Your Ref: OWPC23470
Our Ref: A/55/19/PL 30-04-2019
Please ask for:
Mrs A Gardner

Construction of 1 No. new two storey house (resubmission following A/31/19/PL). This application is a Departure from the Development Plan & affects a Public Right of Way.

Land between Ashurst and Badgers Ham Manor Way Angmering

Site Location Plan (1:1250)

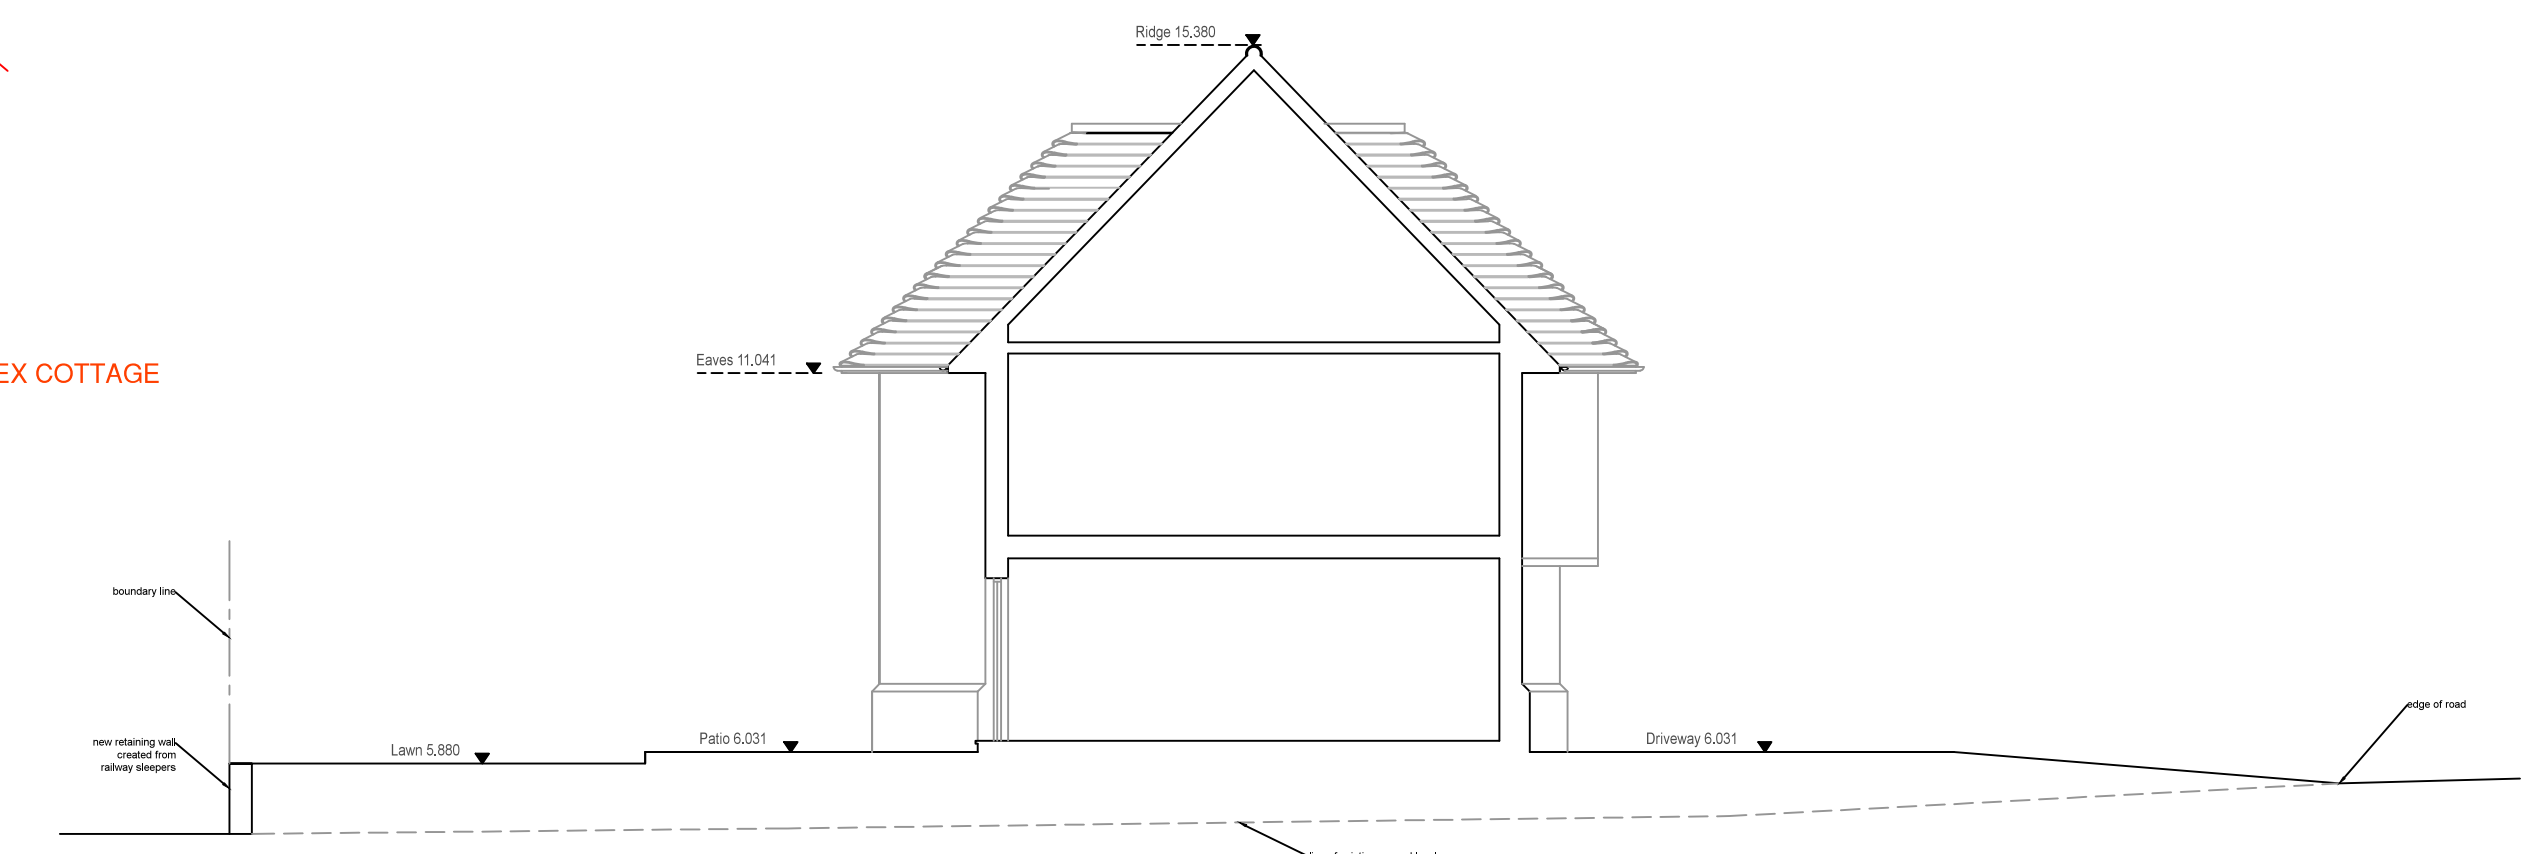
The most recent application ADC application A/31/19/PL was rejected on 29th April 2019 on the grounds that the position of the dwelling within the golf course, which is designated as a Local Green Space in the ANDP, would represent an unacceptable incursion into the area and would constitute a prominent form of development which would adversely affect the character and appearance of the area in conflict with policies CSP1, DDM1 and OSR DM1 of the Arun Local Plan

Client: Mr & Mrs Jones
Project Address:
Land at the 9th Tee
Ham Manor Way
Angmering
Drawing Title:
Proposed Plans, Elevations and Street
Scene Elevation
Drawing Number: 1202.01.d
Scale: As stated printed @ A1
Date: 06/02/2019

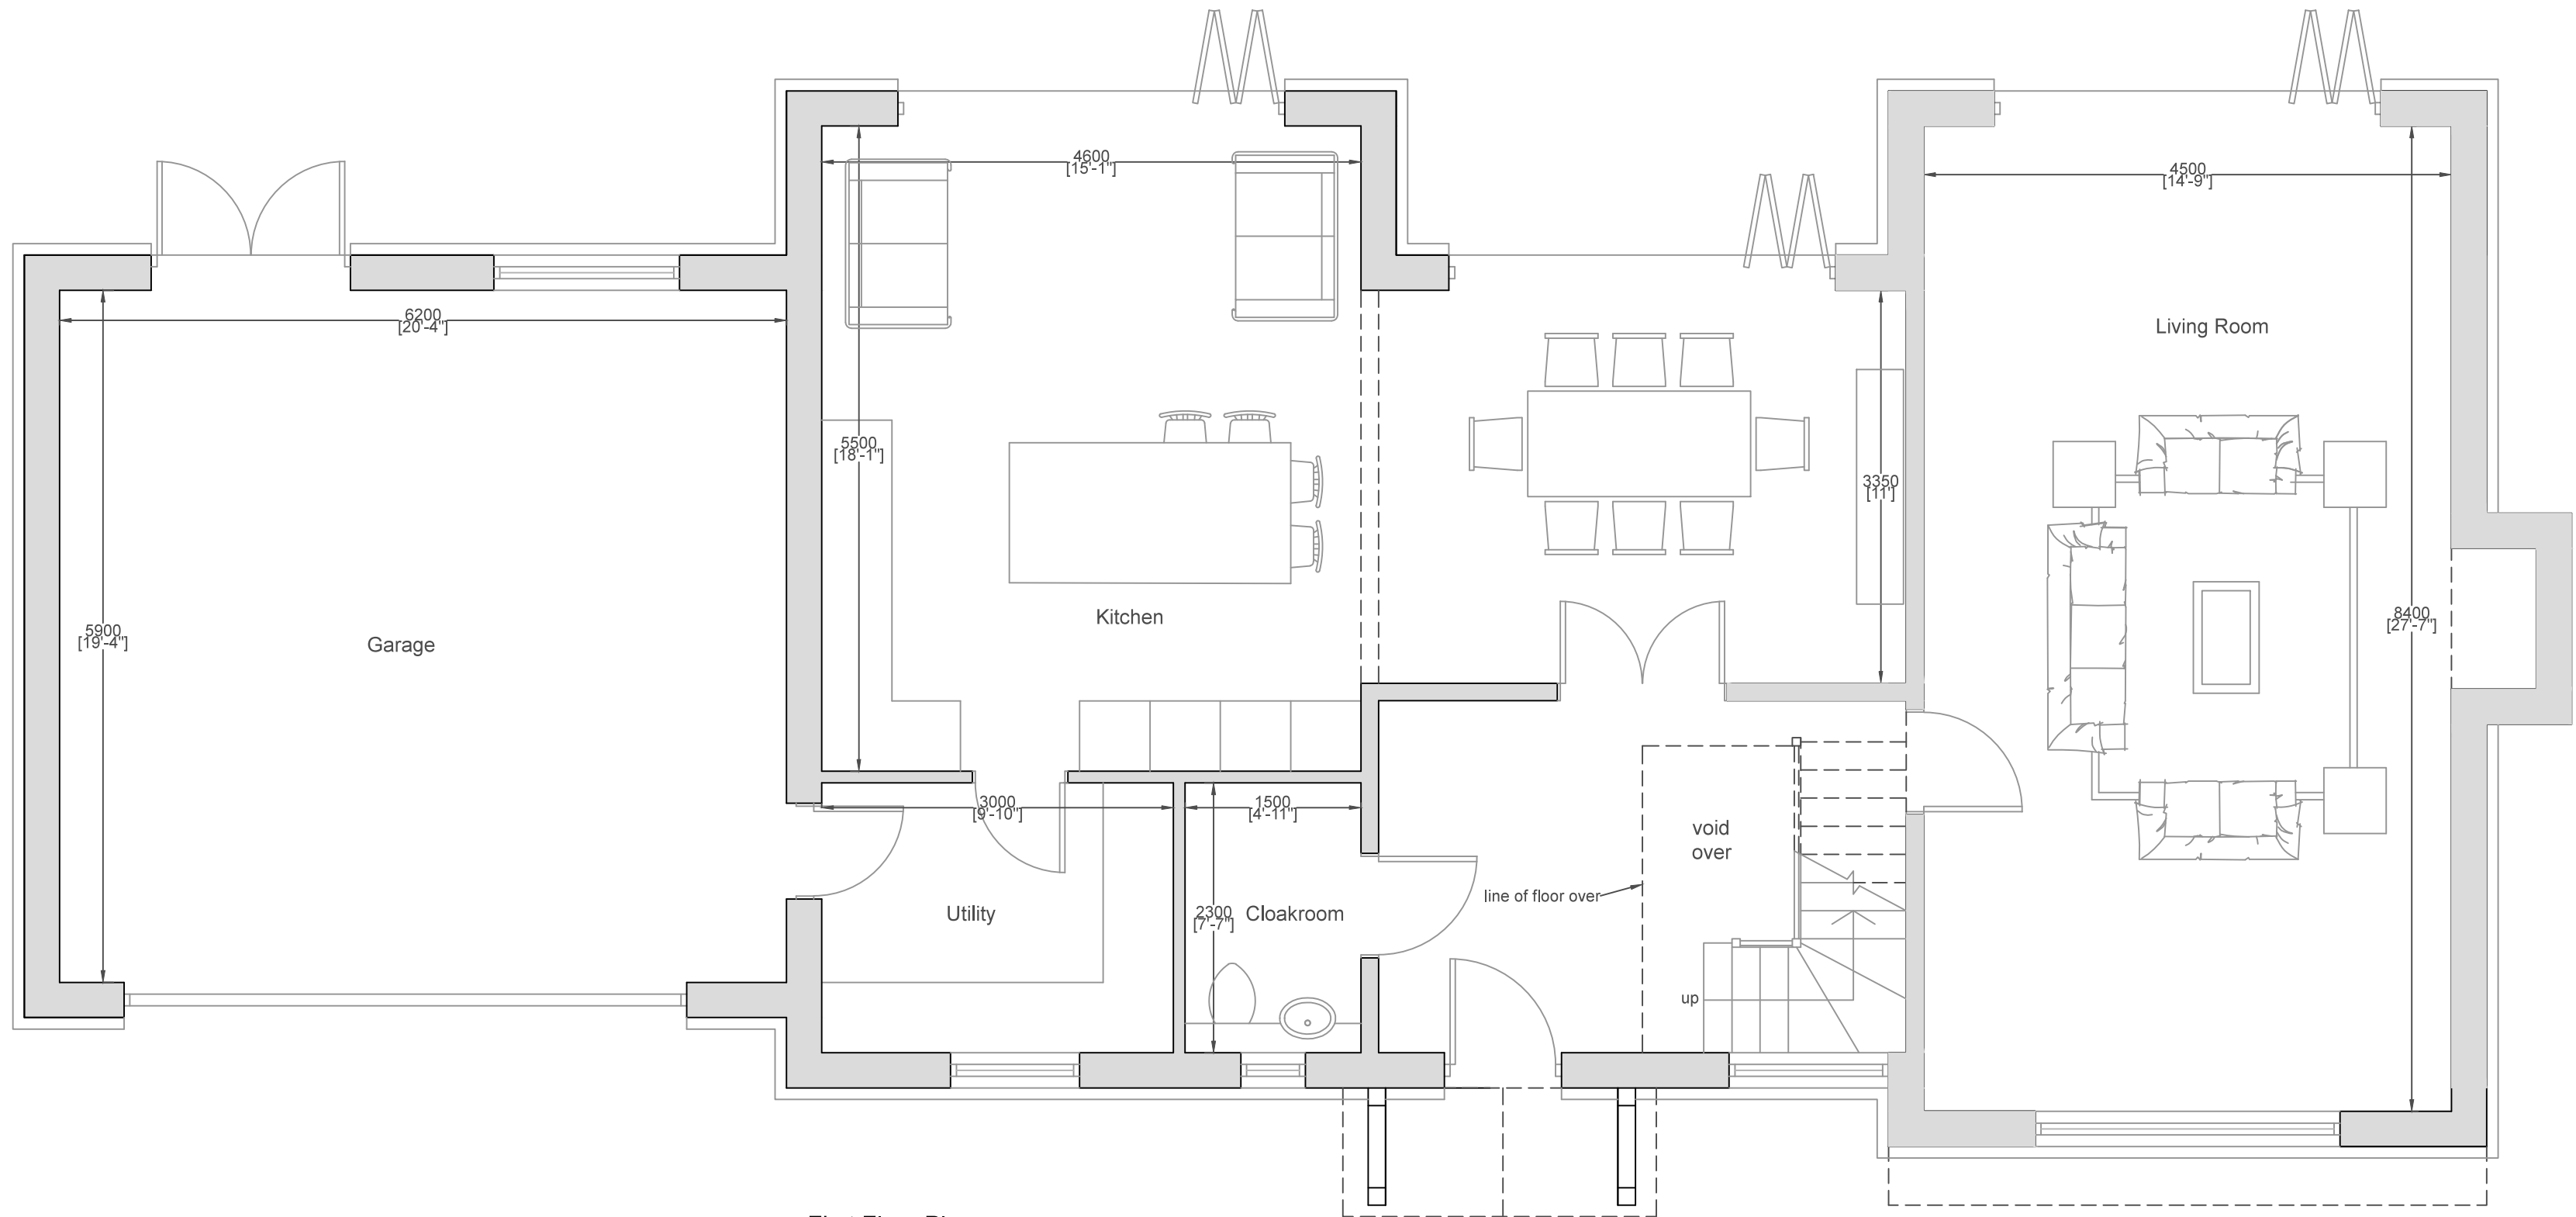
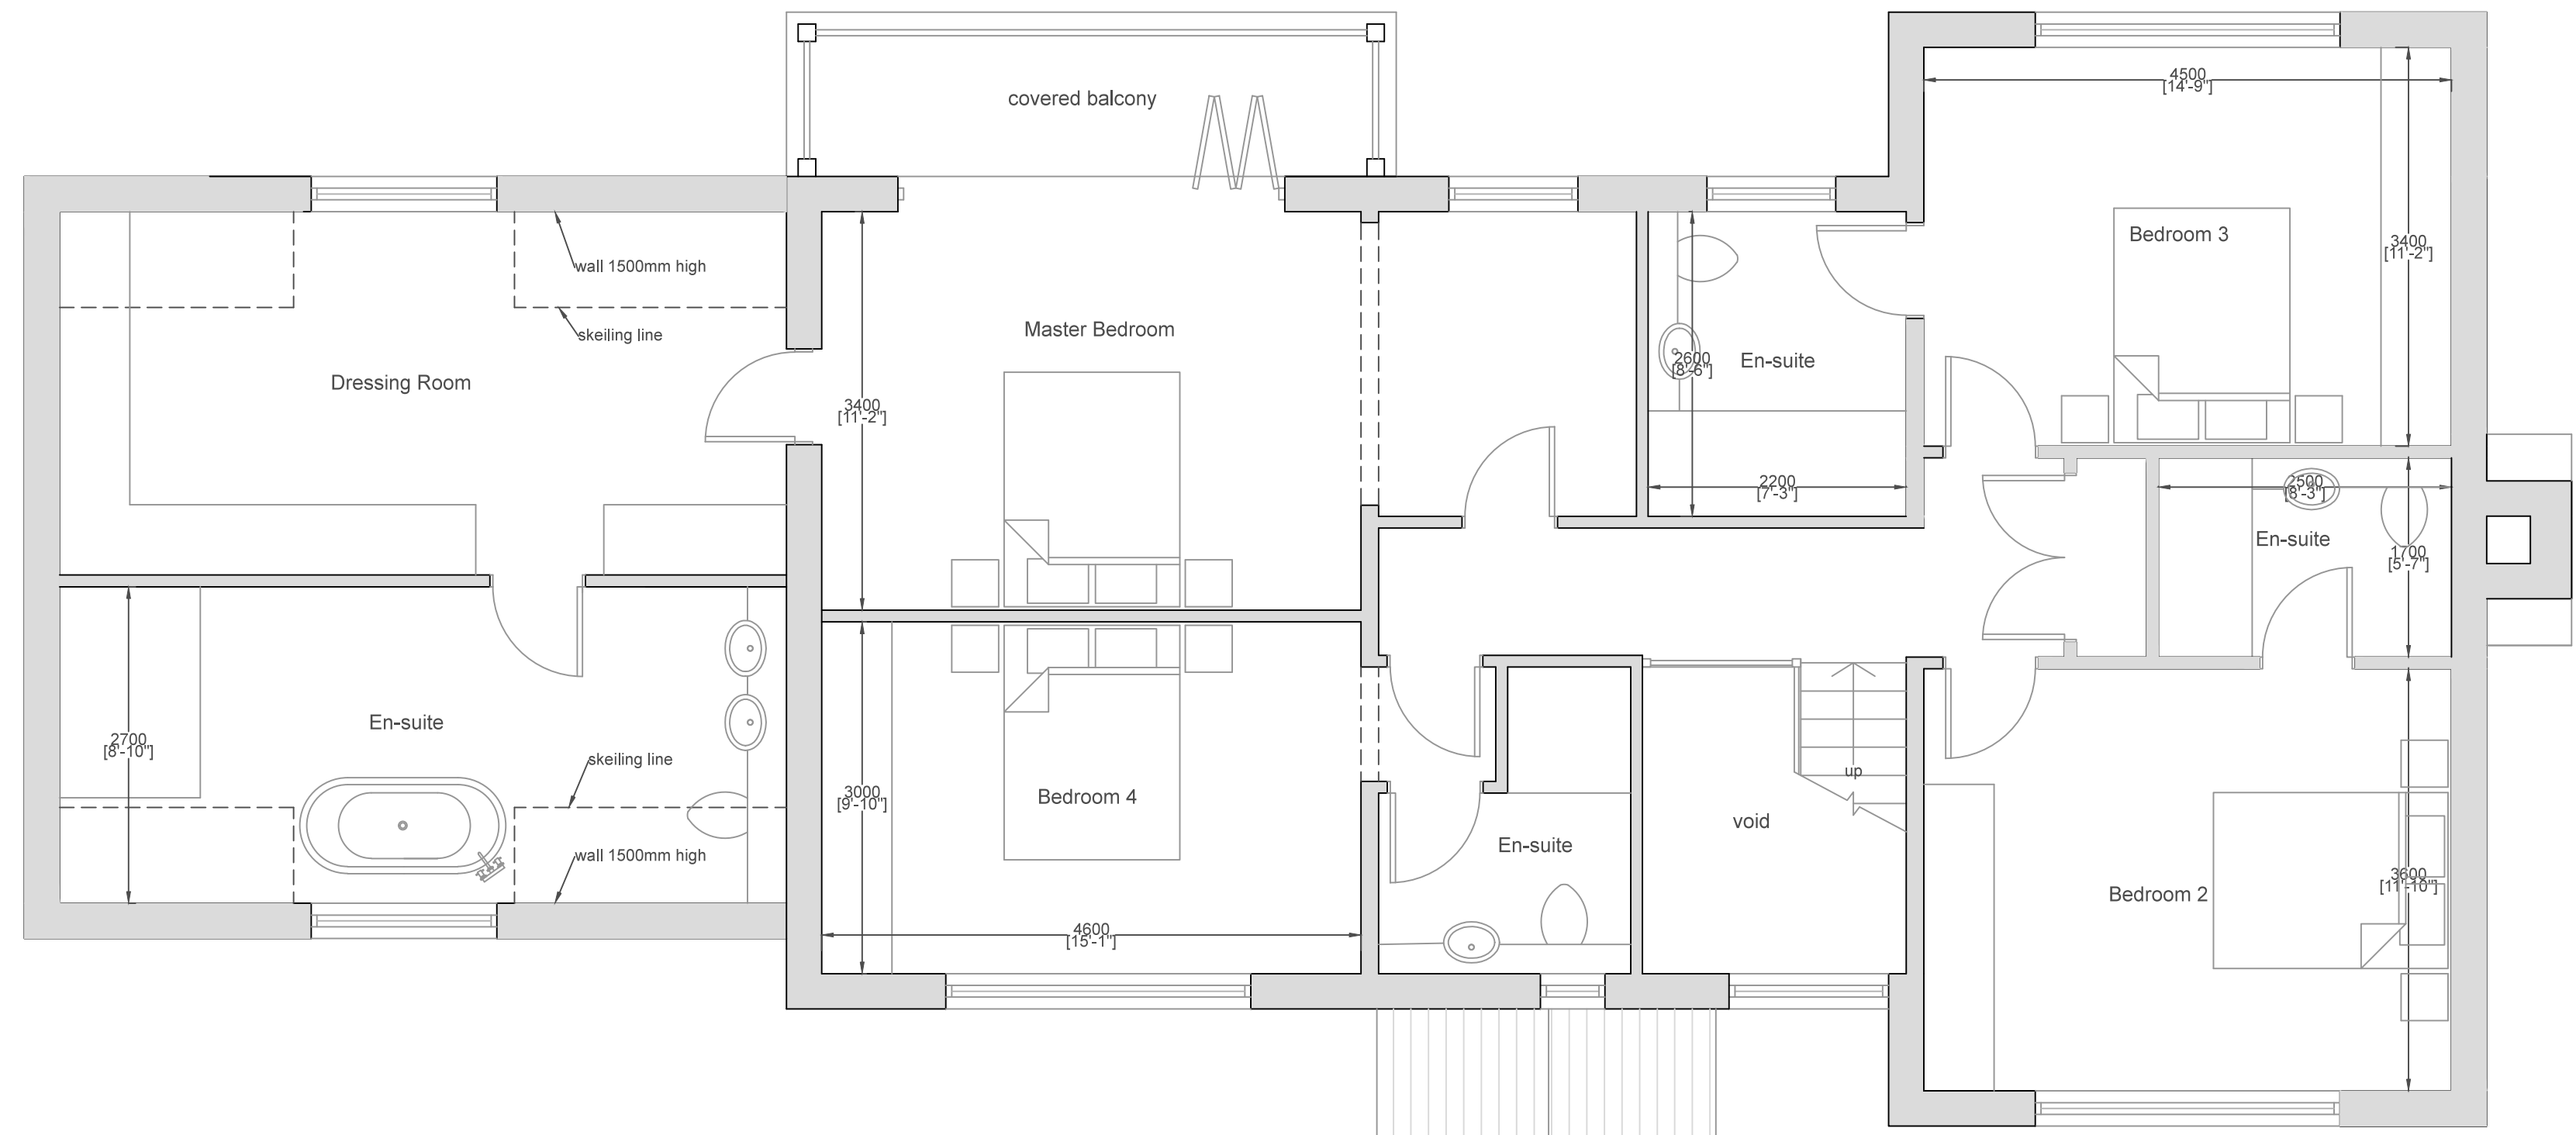
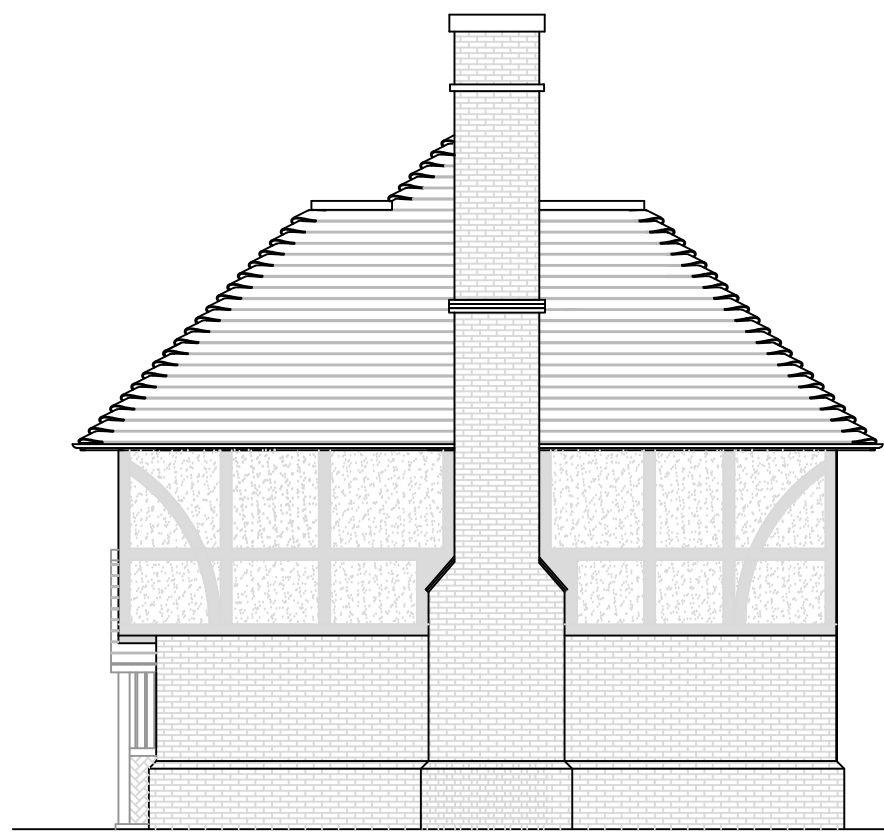
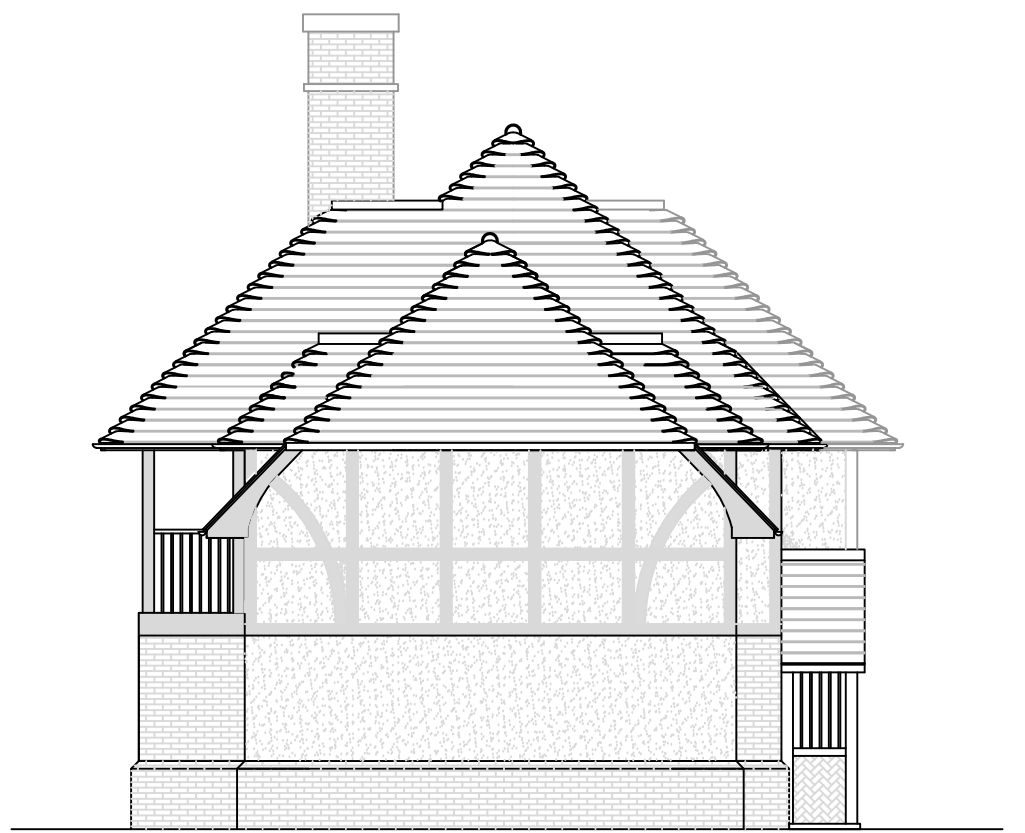
** The applicant makes much of the fact that the proposed dwelling is similar in size and design to Badgers, the nearest house situated to the north of the site. Yet, opposite and adjacent to the site, all the other remaining properties are much smaller in size and of bungalow or chalet/bungalow design. The proposed dwelling will be totally out of keeping these surrounding properties.*

** The applicant has submitted plans for one house on one of the two plots covered by the CLD stating that the remaining plot is to be used as a garden for the dwelling. However, the plans do not provide for any windows or doors on the garden south side of the dwelling. It is quite clear from the plans and drawings that, if the applicant is successful with this application, it will only be a matter of time before another application will be submitted for a second large property to be built on the remaining "garden" plot. Should the council be of a mind to grant this application, then in order to maintain the dwelling to plot ratio and the open nature of the location, consideration should be given to the issuing of a section S106 notice to cover the adjoining garden plot.*

** In conclusion, Ham Manor Way is a public Right of Way and as such is used by many villagers and residents for recreation and walking of dogs. Building of the proposed dwelling, with such a high and wide frontage would greatly diminish the striking views afforded across the golf course and the open countryside beyond.*
Kind regards
